From: Dunderdale, Chris <
Sent: 22 June 2021 11:45
To: Adam Birkett <
Cc: Brenton, Robert <
Subject: FW: Whalley Road, Barrow, PLANNING APPLICATION NUMBER 3/2018/1149 - discharge of condition 7

Thank you for re-consulting us on planning application 3/2021/0203. I've had a quick look through the information provided (drawing ENG001 Rev P10 and supporting flow calculations) and I've identified the following issues/discrepancies:

S104 Drainage Layout

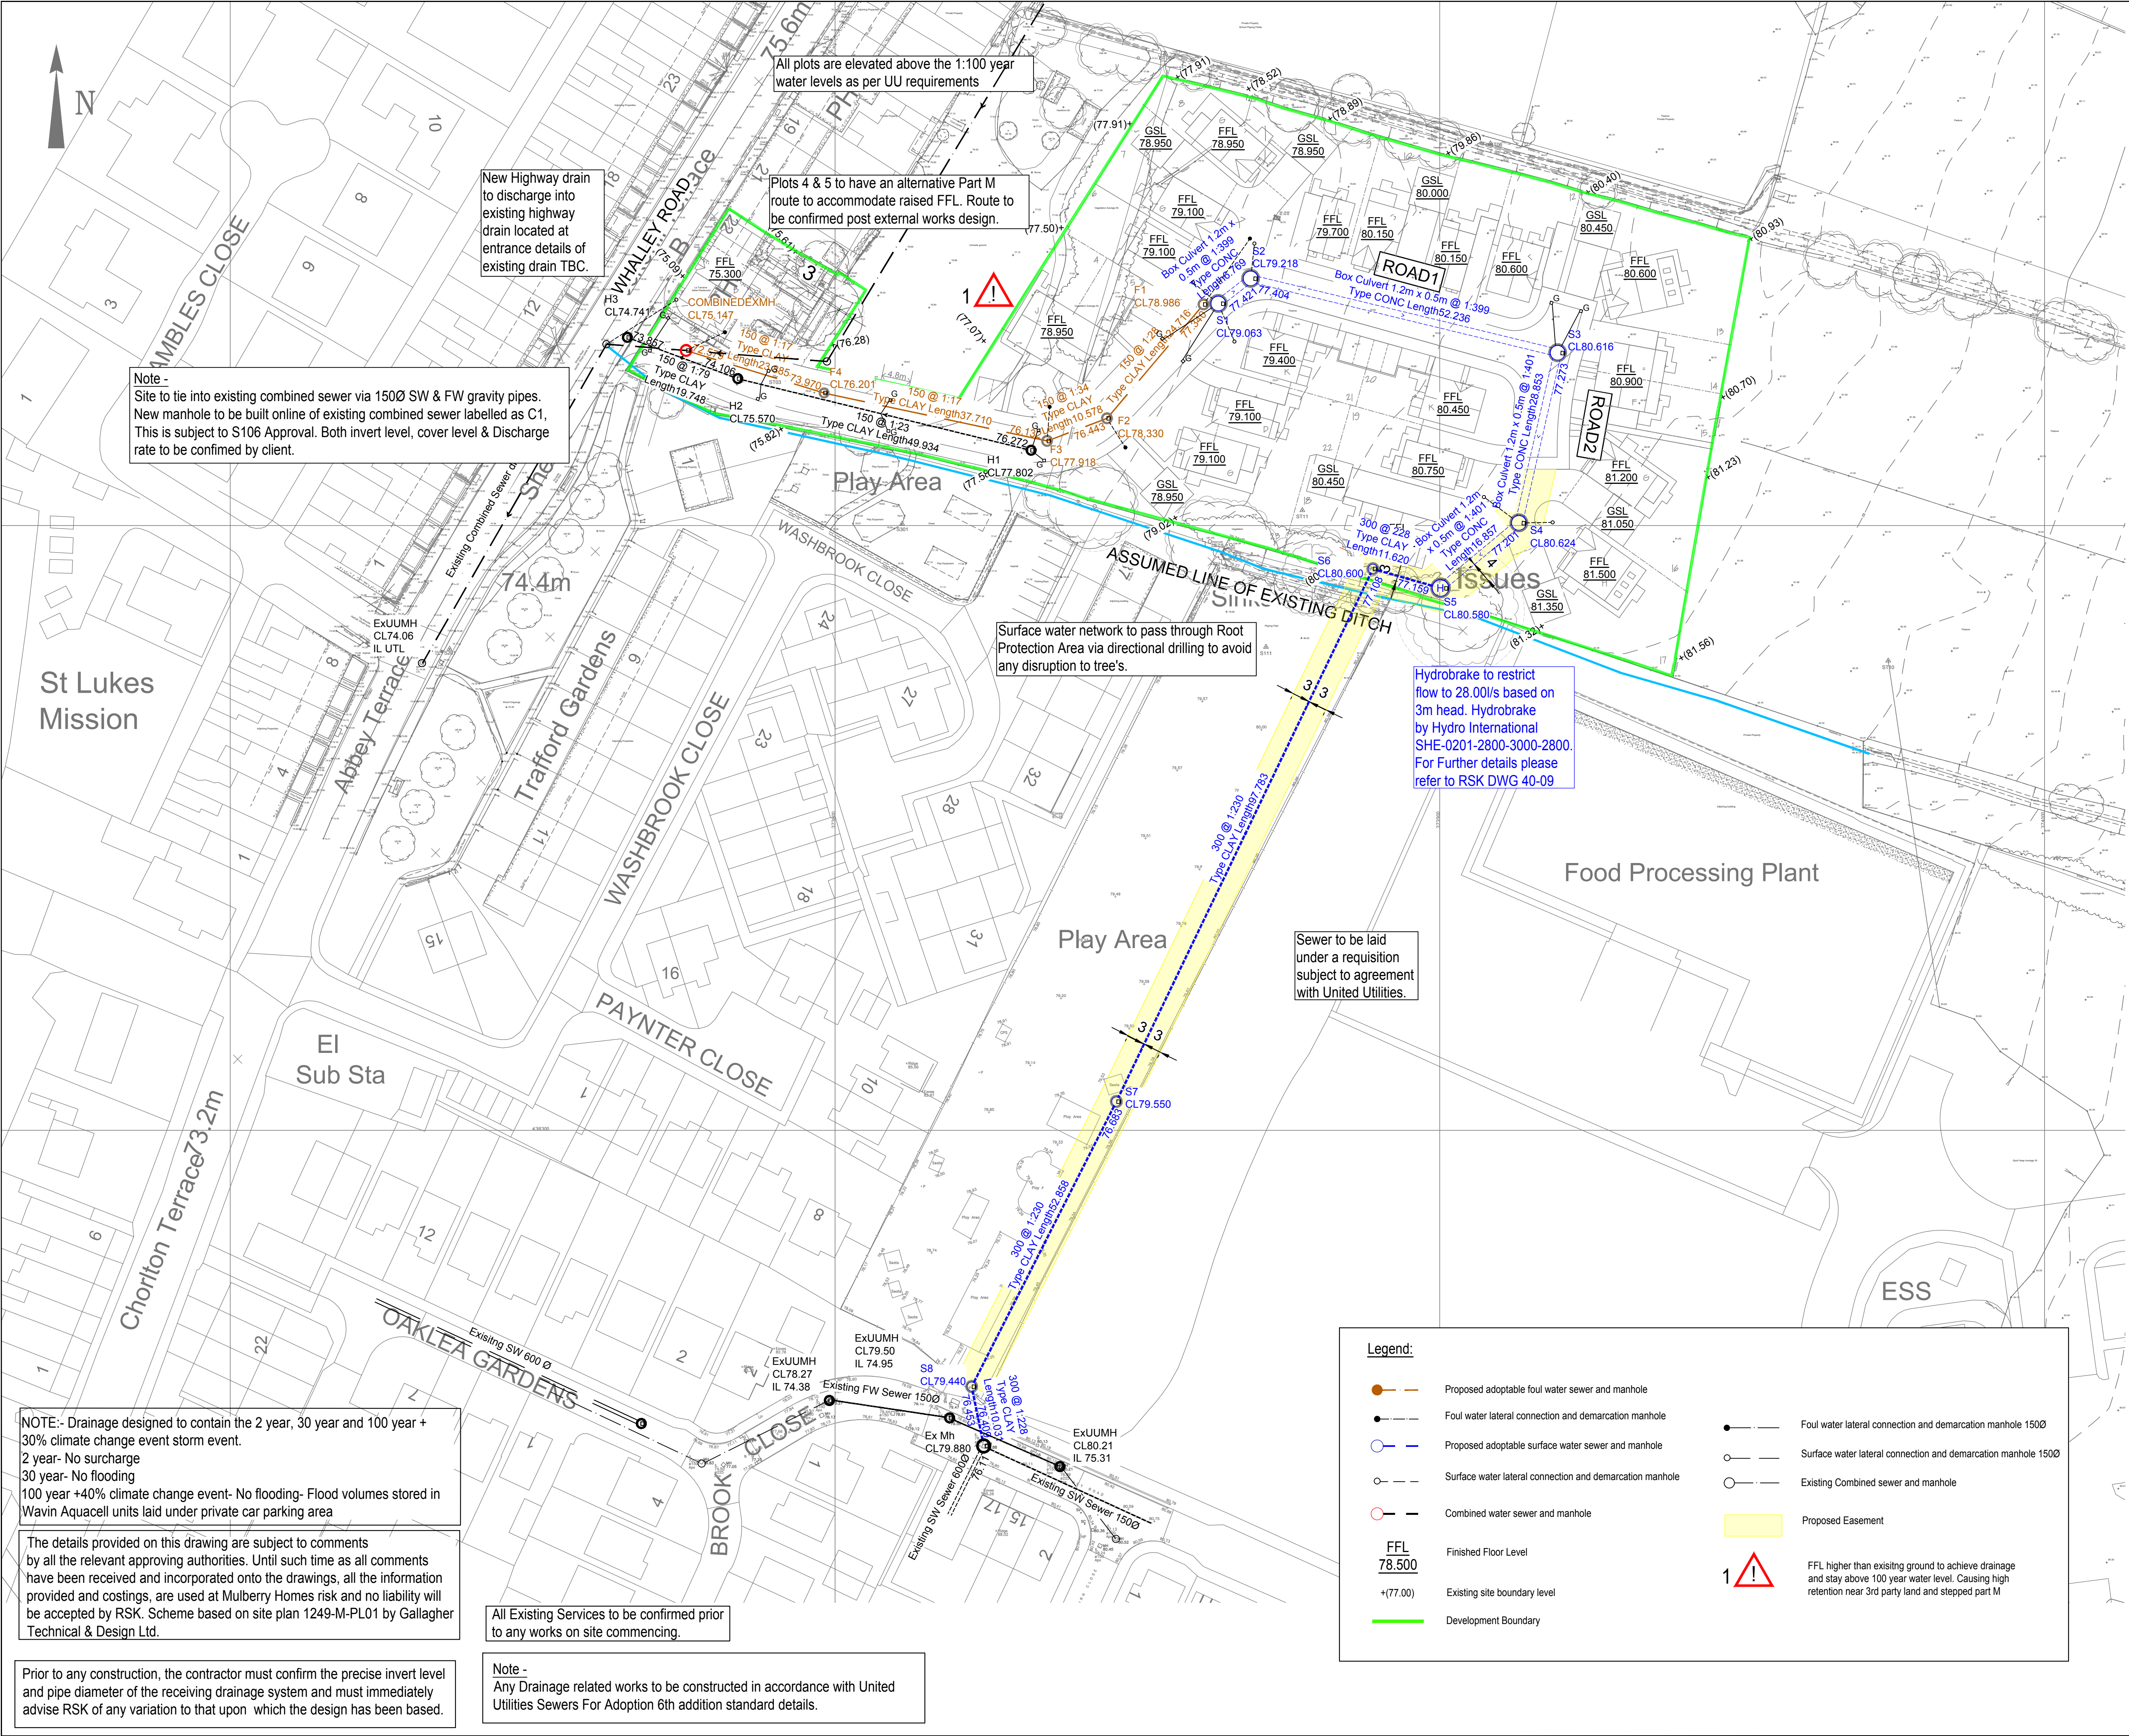
- Pipe number S1.002 is shown as a 150mm diameter pipe on the drainage layout plan, but it's been modelled as a 1500mm diameter pipe according to the supporting flow calculations. Please can this be checked by the applicant and amended for accuracy?

- According to the annotations on the drainage layout plan, an additional 10% allowance has been included within the drainage design to allow for future urban creep. It's not clear to me from the calculations how this 10% allowance has been applied. Please can we have some further clarification on this?

- It's not clear whether the drainage network has been modelled with a free flowing outfall or with a surcharged outfall. Please can we have some further clarification on this? For the avoidance of doubt, we'd expect for the drainage network to be modelled with a surcharged outfall, unless it can be demonstrated that a free flowing outfall can be achieved.
